**From:** [Oliver, Lewis](#)  
**To:** [Aquind Interconnector](#)  
**Subject:** Application by AQUIND Limited for an Order Granting Development Consent - deadline 4 submission  
**Date:** 16 November 2020 18:02:12  
**Attachments:** [image001.png](#)  
[Table HBC Deadline 4 responses.pdf](#)

Application by AQUIND Limited for an Order Granting Development Consent for the AQUIND Interconnector Project

In accordance with the published Rule 6 letter, please find attached the following from Havant Borough Council to comply with deadline 4. The responses attached relate to the applicants submission Document ref: 7.9.6 - Applicant's Response to Deadline 2 Submissions.

Table 2.2 – Havant Borough Council

**Plate 2.13 – Alternative Countryside Routes (as proposed by WCC and HBC)**

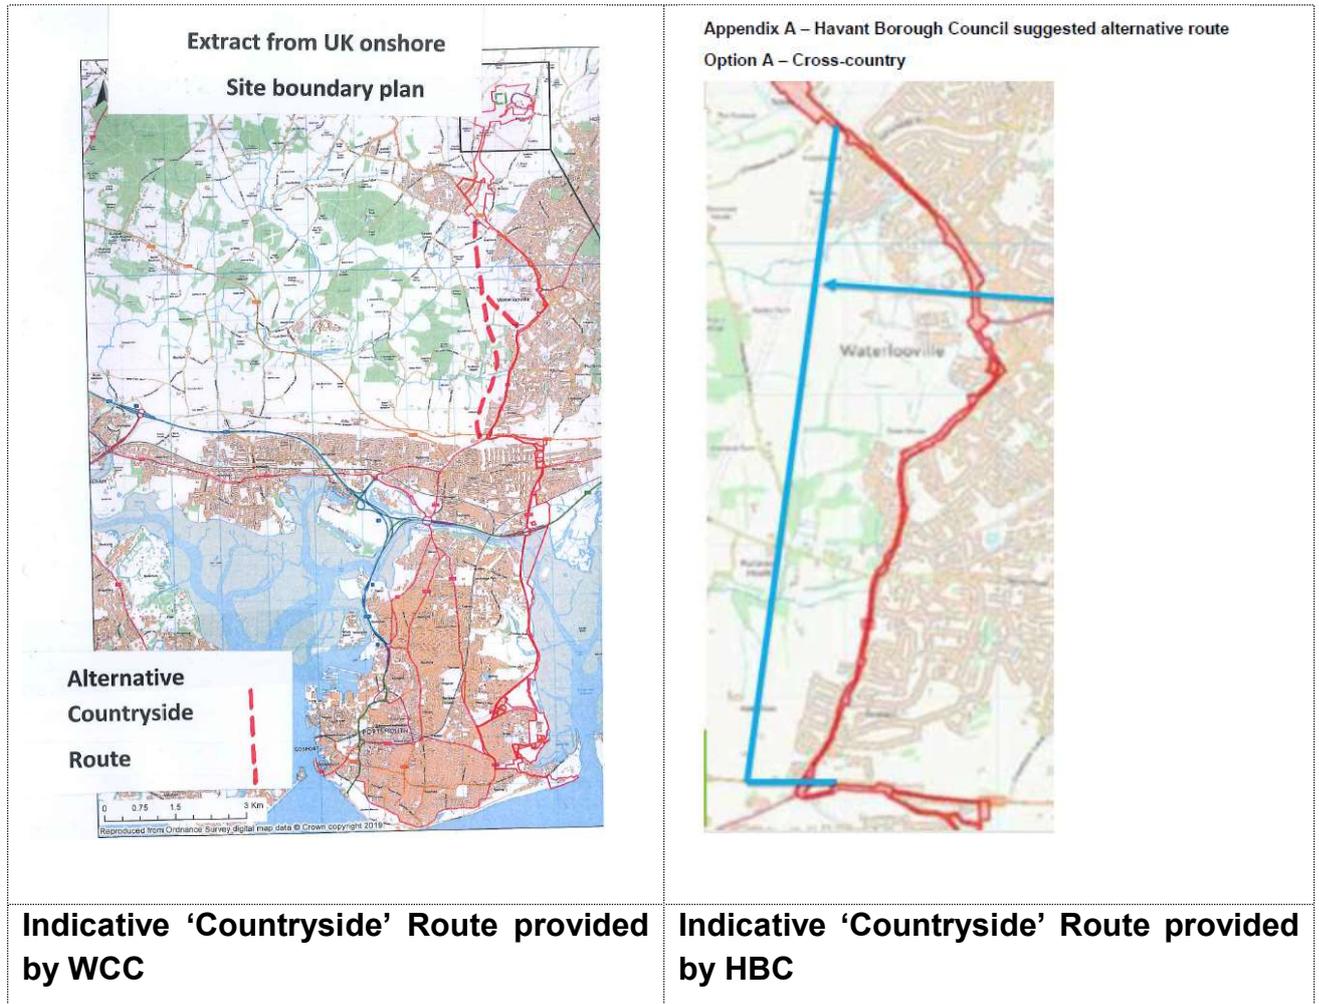
Para No.	Applicants response	HBC Comment
<b>Alternative Route Opportunities</b>		
4	<p>The consideration of a cable route in this location was first considered in 2017, however it was discounted at this stage because of the potential for environmental impacts on designated sites and the because the Applicant did not want to sterilise the land in this location, noting that it is an area allocated for housing development. Following the suggestion of the alternative countryside routes by HBC and WCC in responses provided at the AQUIND public consultation on 16th and 29th April 2019, respectively, the potential for a route in those location was further considered to confirm the previous conclusions made.</p> <p>A summary of how the HBC and WCC countryside routes have been considered by the Applicant is provided at section 2.6.4 of ES Chapter 2 (Consideration of Alternatives) (APP-117), submitted as part of the 2019 Application. Further to continued requests for additional information regarding how the Applicant considered these routes, a more detailed explanation of the countryside routes and the reasons why they were not pursued was provided in section 8 of the Supplementary Alternatives Chapter (REP1-152)</p>	<p>HBC notes these comments, however the evidence that the cable route was first considered and selected in 2017 is interesting, we have not seen any evidence that this was considered at this point in terms of a clear audit trail of these considerations. HBC are not prejudging that a countryside would be acceptable, however we do expect that these alternative options to see evidence that this route was considered at the time, rather than retrospectively ruling this potential option out, after the highway route had already been selected. This remains a concern to HBC.</p>

<p>The Applicant confirms it is content with the approach taken to considering the Countryside Route in a proportionate manner, and with the reasons for the route it has selected when balancing the potential for impacts on the natural environment and the sterilisation of land for a significant period as opposed to the temporary impacts associated with installing utilities infrastructure in the highway.</p>	
<b>Sterilisation of land</b>		
6	<p>It is not possible to mitigate the sterilisation of land where the cable circuits are laid along the suggested Countryside Route. Taking into account that the Project has the operational life of 40 years from the start of operations, the suggestion of placing not insignificant constraints on the land with future development being laid out around this without issue is fanciful and shows a want of understanding of technical and commercial realities. It would be an unnecessary constraint to any future development coming forward in this location, which would potentially deter development and at best would be complicated to address. As can be seen from the long history of the West of Waterlooville MDA, the delivery of development is not an uncomplicated matter, and by including additional constraints such as this feasibility and viability of future development would undoubtedly be affected. It is, of course, best avoided.</p> <p>The Applicant also confirms that the sterilisation of land for future development is not the only reason for discounting any cable route. The Applicant has considered and balanced the relevant considerations in relation to the alternatives studied (as set out in the Supplementary Alternatives Chapter (REP1-152)) and has reached reasonable and logical conclusions.</p>	<p>HBC are one of two Local Planning Authorities which contains the West of Waterlooville MDA and fully understand the issues associated with this development. Elements of the scheme could have potentially been routed through the MDA, if it were timed appropriately with the ongoing infrastructure provision of this development. Again, HBC acknowledge that a route might not be possible for such a route to undertaken, however the evidence provided appears to retrospectively rule this matter out.</p>

7	<p>The constraints maps contained in Appendix 4 (Ecological Constraints Map of the Countryside Routes) of the Supplementary Alternatives Chapter (REP1-152) show similar environmental constraints, such as SINCs, woodland and grazing marshes, to the west of the Countryside routes that would also need to be considered in terms of balancing the various impacts against one another. The temporary adverse impacts of laying the cables in the highway are, in the Applicant's view, outweighed by the temporary and permanent impacts of laying the cables in the location of the Countryside Routes. Whilst mitigation could be deployed, the residual impacts of such a route mean it is not preferred, and for this reason it was</p>	<p>HBC are not suggested that any routing should jeopardise housing delivery, HBC are outlining that consideration should be given to the delivery of housing, however that are many routes to get towards the convertor station. We are having outlining that site selection can consider innovative ways to overcome the designations that have been highlighted.</p>
